CITY OF ALBUQUERQUE

RE: 2440 Louisiana Office Bldg
Conceptual Grading & Drainage Plan
Engineer's Stamp Date: 01/17/22
Hydrology File: H19D084

Based upon the information provided in your submittal received 01/21/2022, the Conceptual Grading & Drainage Plan is **not** approved for action by the DRB on Site Plan for Building Permit. The following comments need to be addressed for approval of the above referenced project:

INLET NO.	CONTRIBUTING BASINS	TOTAL Q
1	1 - 6.7 cfs 3B - 0 cfs 1/2 of 2 - 0.2 cfs	6.9 cfs
2	3A - 0.4 cfs 4 - 7.7 cfs 1/2 of 2 - 0.2 cfs	8.3 cfs
3	5 - 4.2 cfs	4.2 cfs

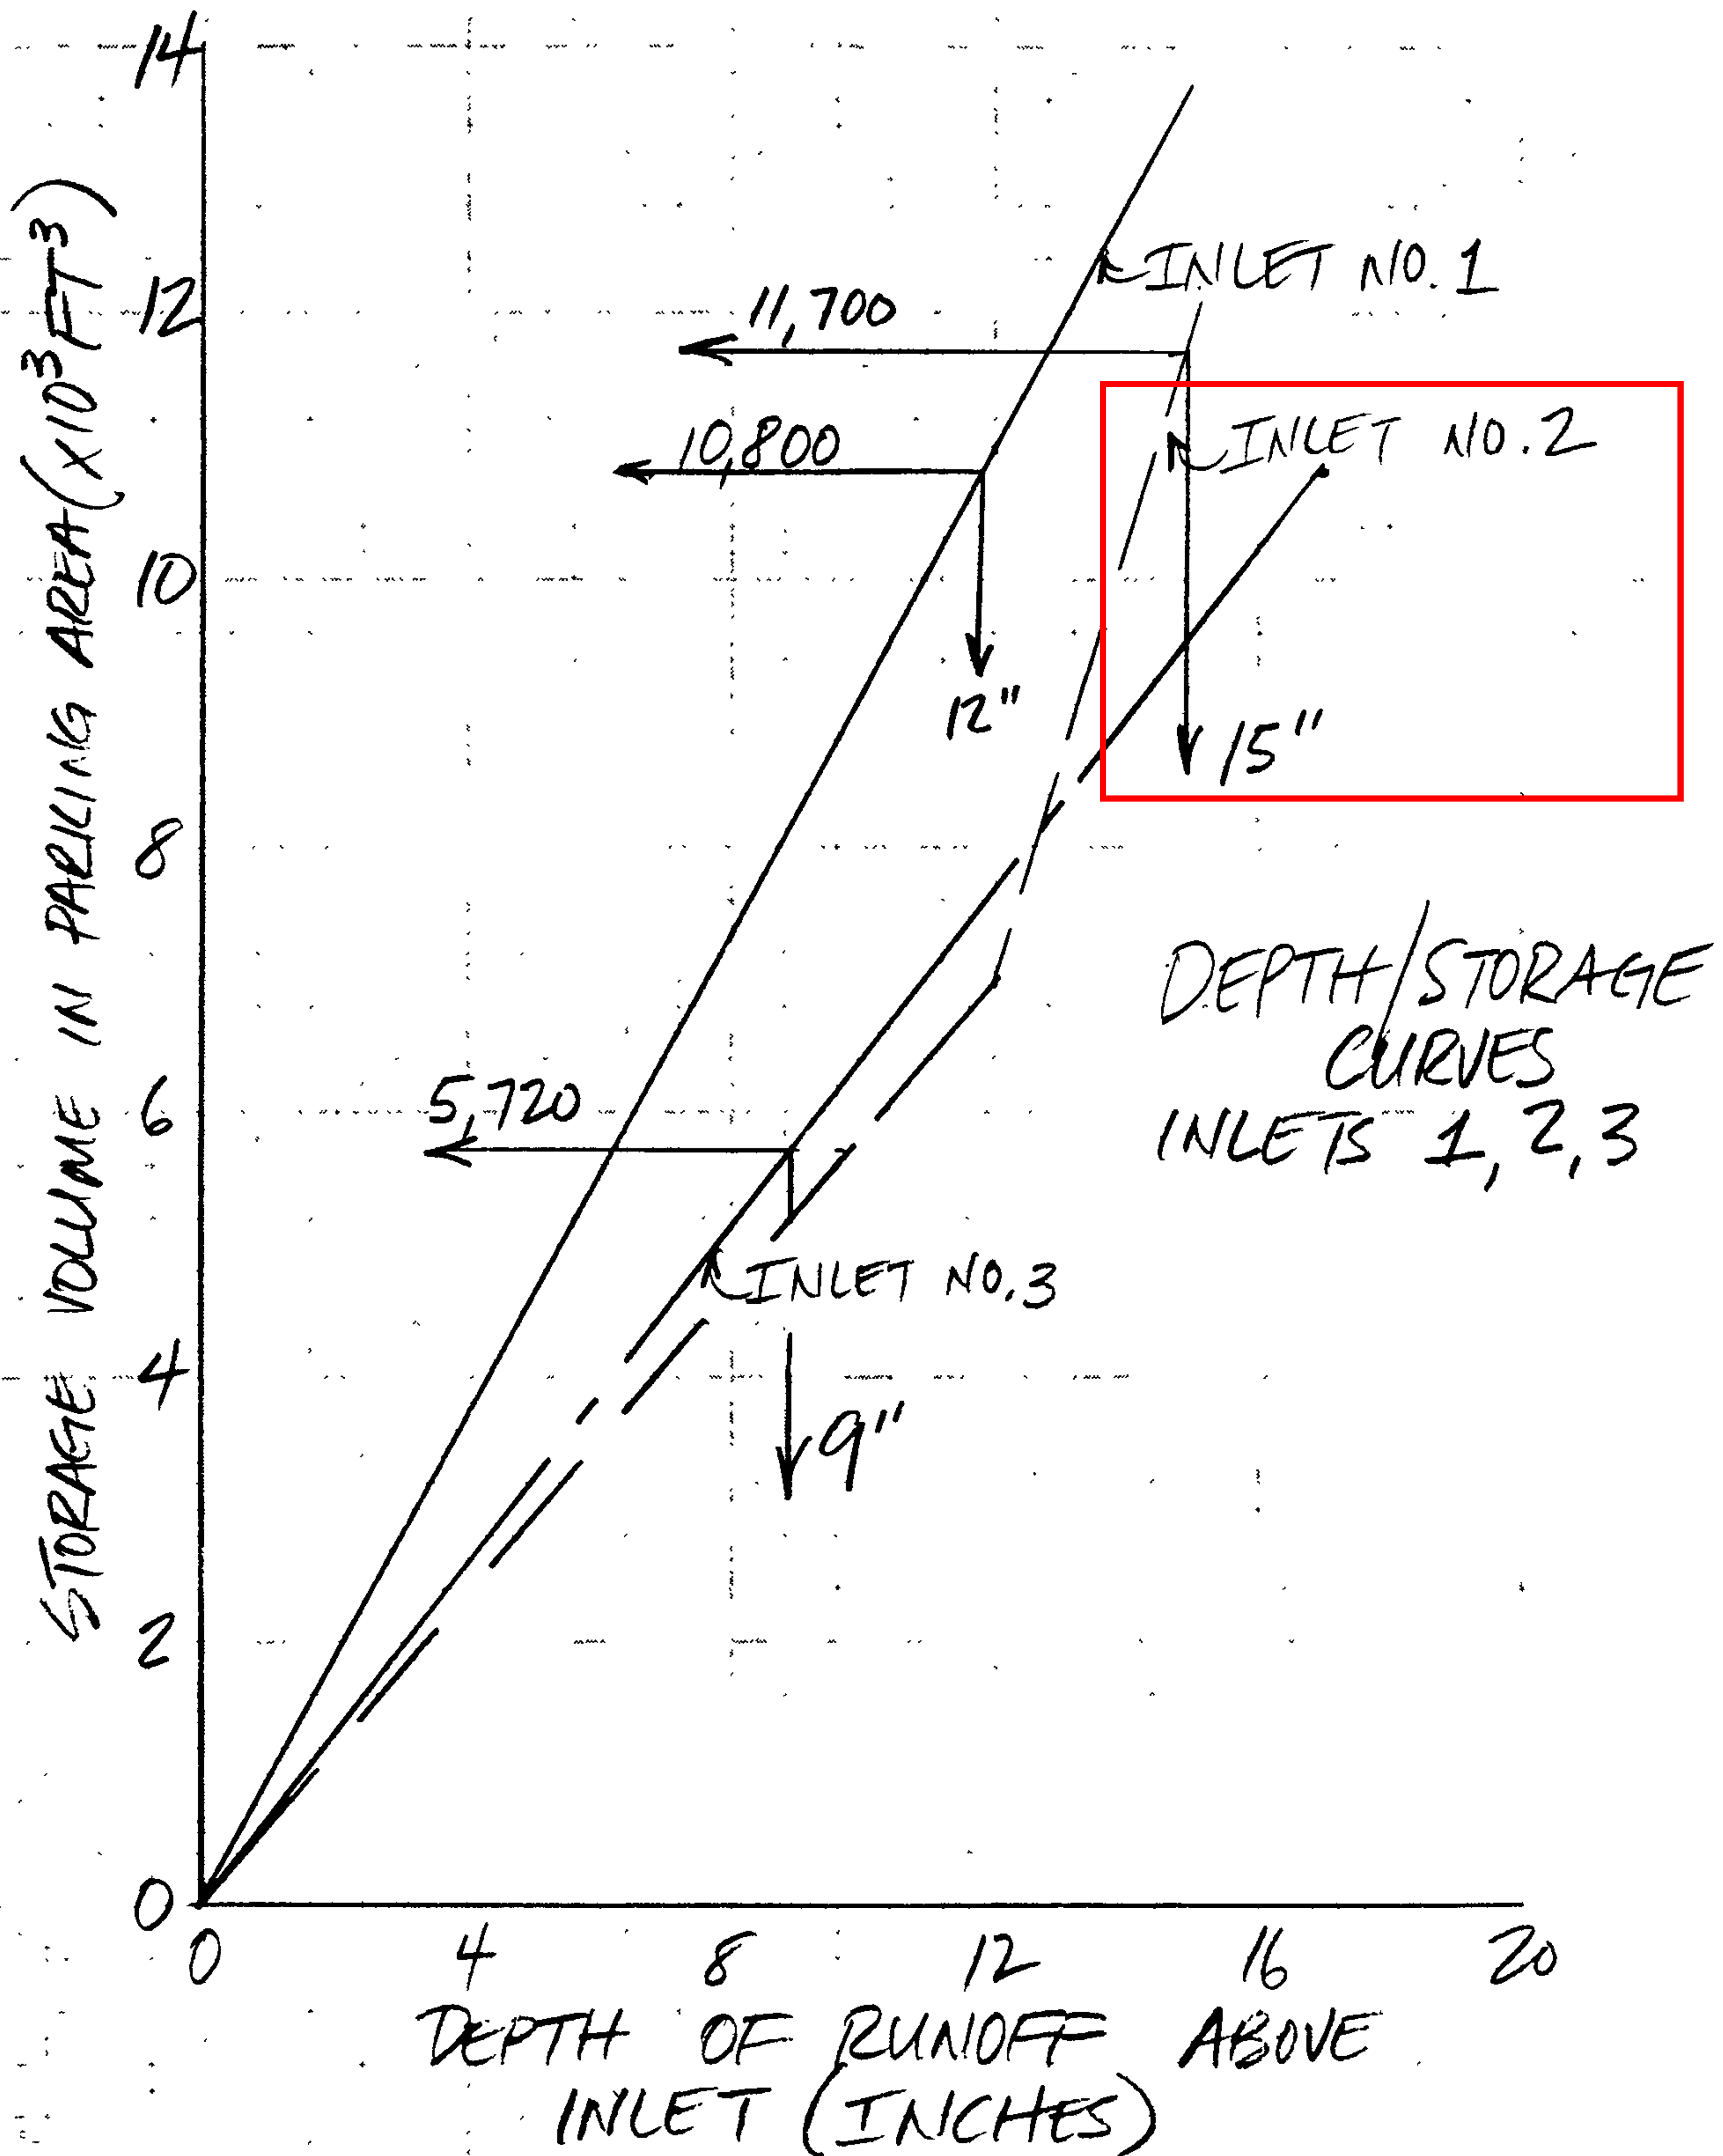
Since it looks like a large portion of detention basin #5 is being removed, an underground system will have to be utilized and outfall to the existing inlet on Louisiana. Also, since Basin #4 ties into Basin #5, Basin #4 will also have to be re-evaluated to determine that it can still provide the required detention.

A1 CONCEPTUAL GRADING & DRAINAGE PLAN
1" = 20'-0"

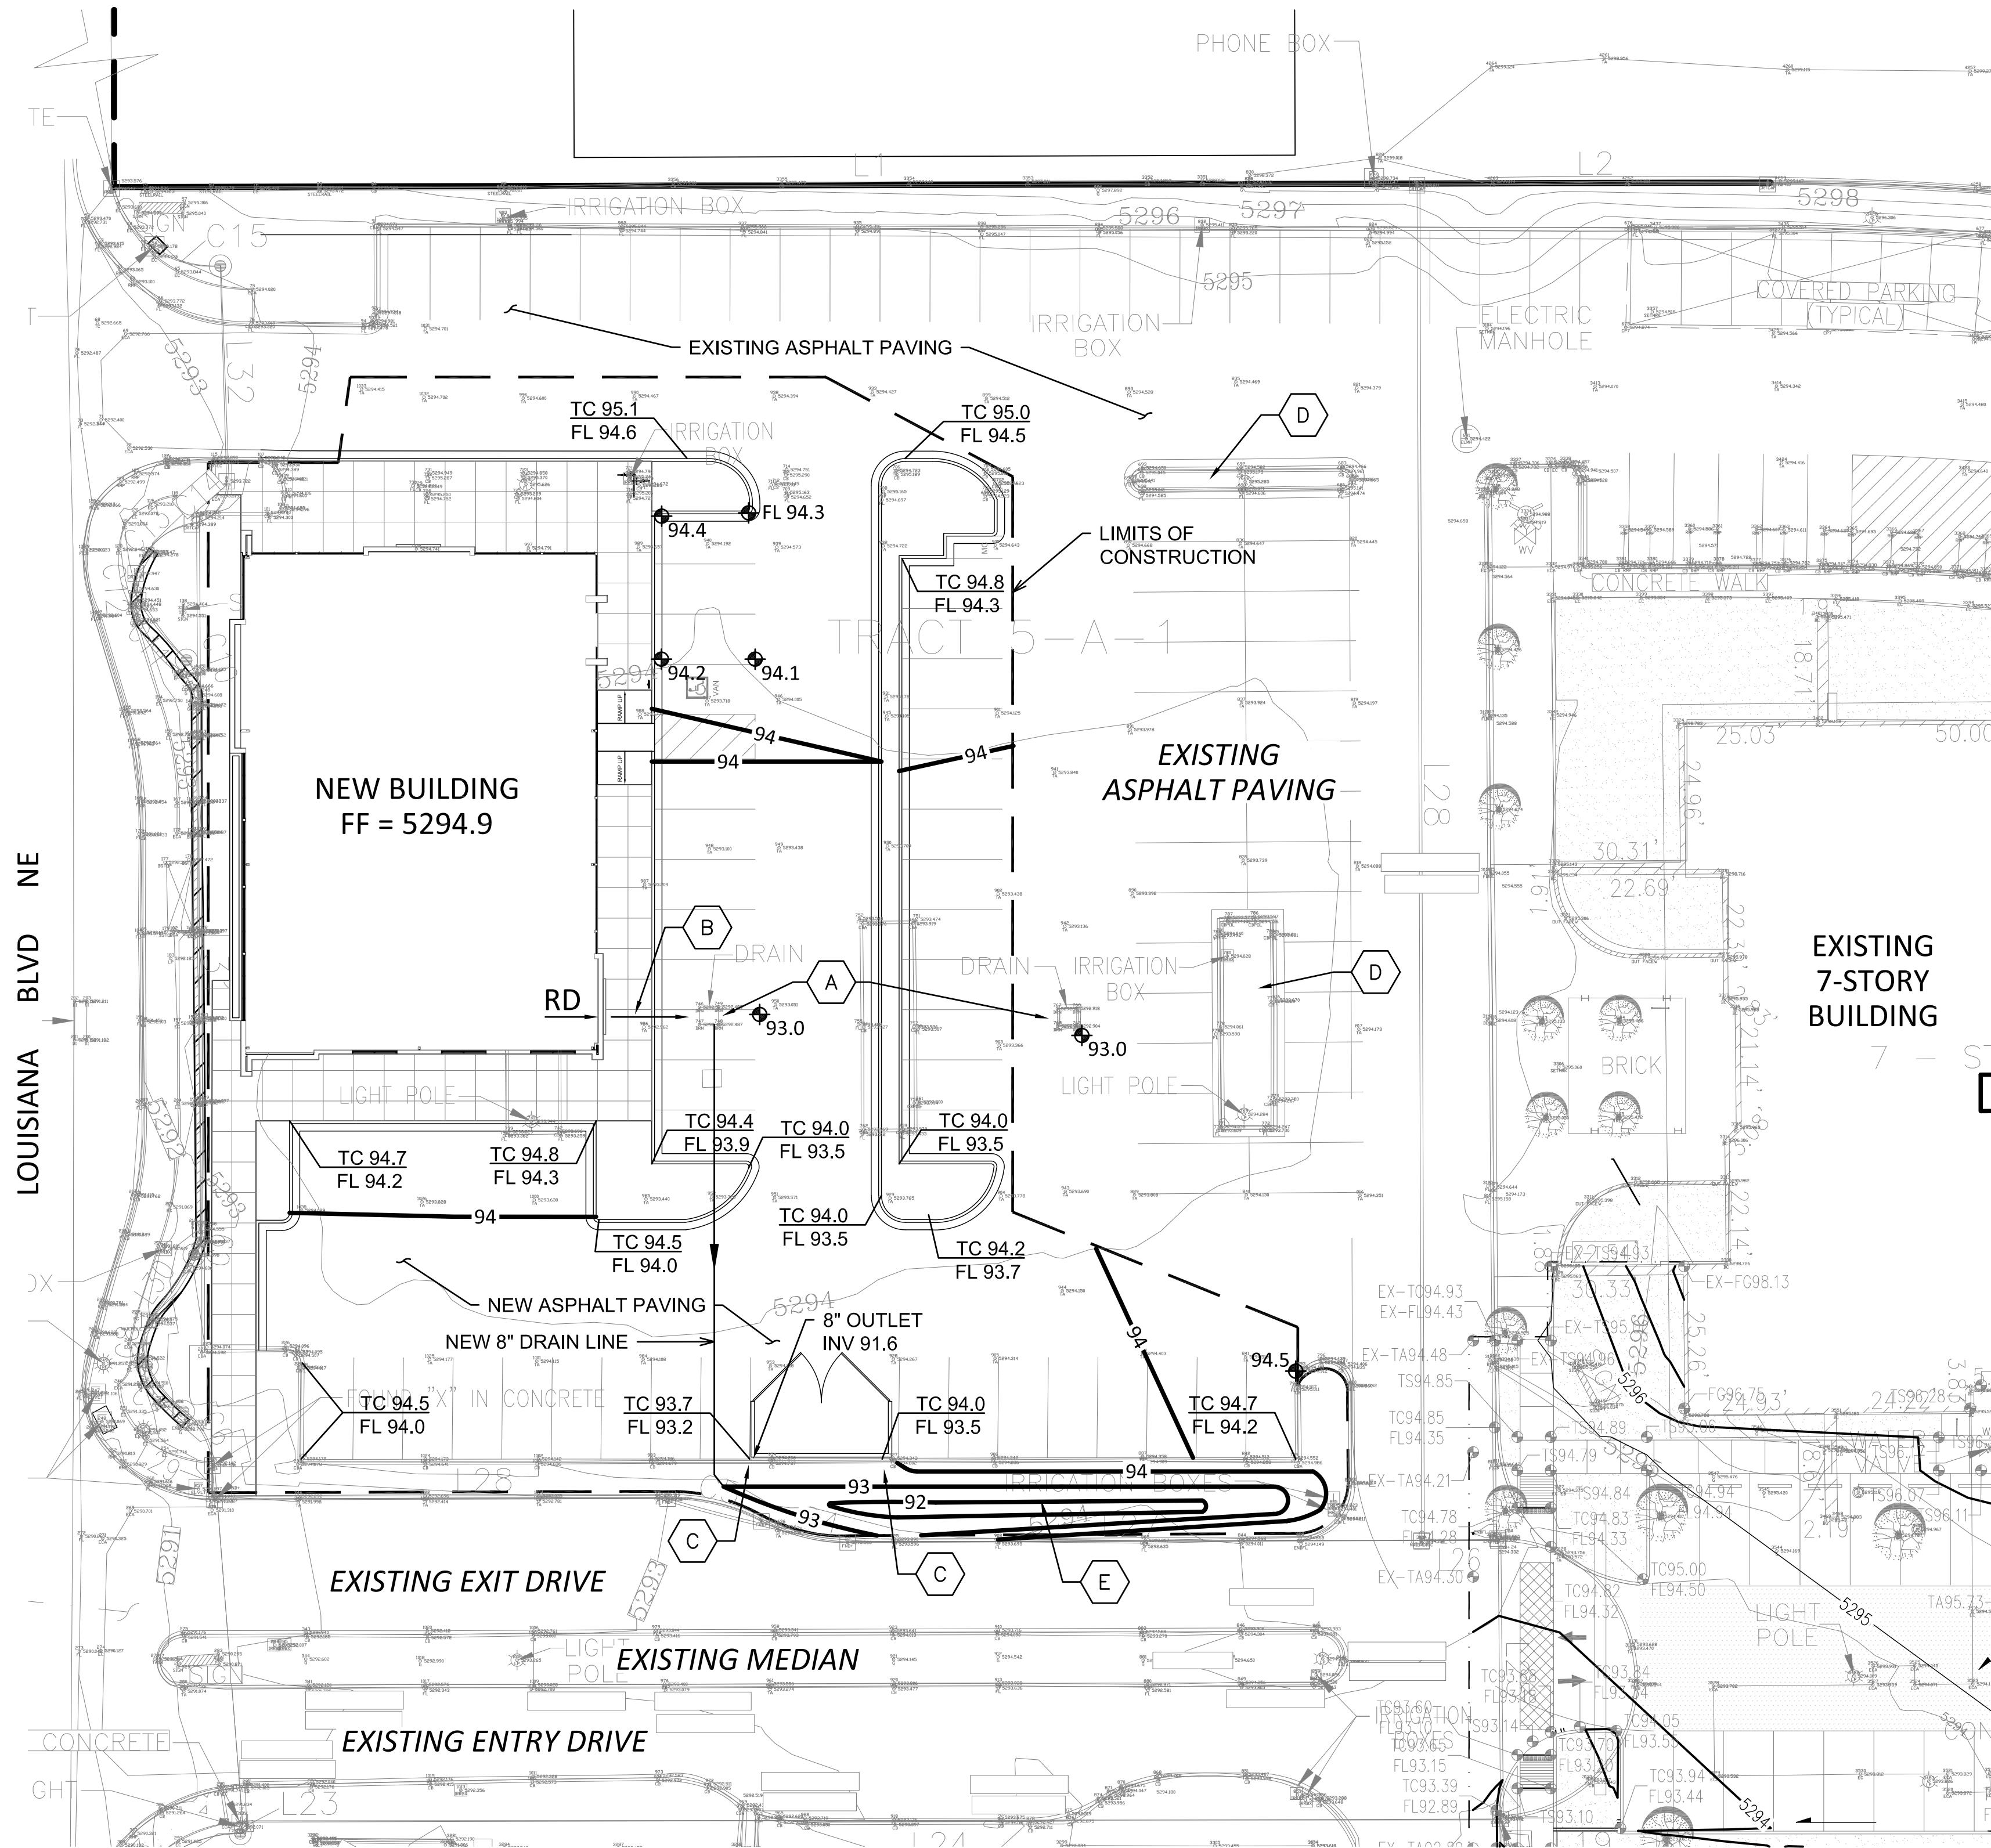
1. Under Existing Conditions, reference to prior drainage file H16-D1 is inaccurate. The actual drainage file is H19D084. According to this drainage plan, this site has limited discharge. See attached plan and calculations.
2. Below is an image of the existing parking with two ponding area utilizing the parking and adding about 15 inches above the inlets to store the detention volume.
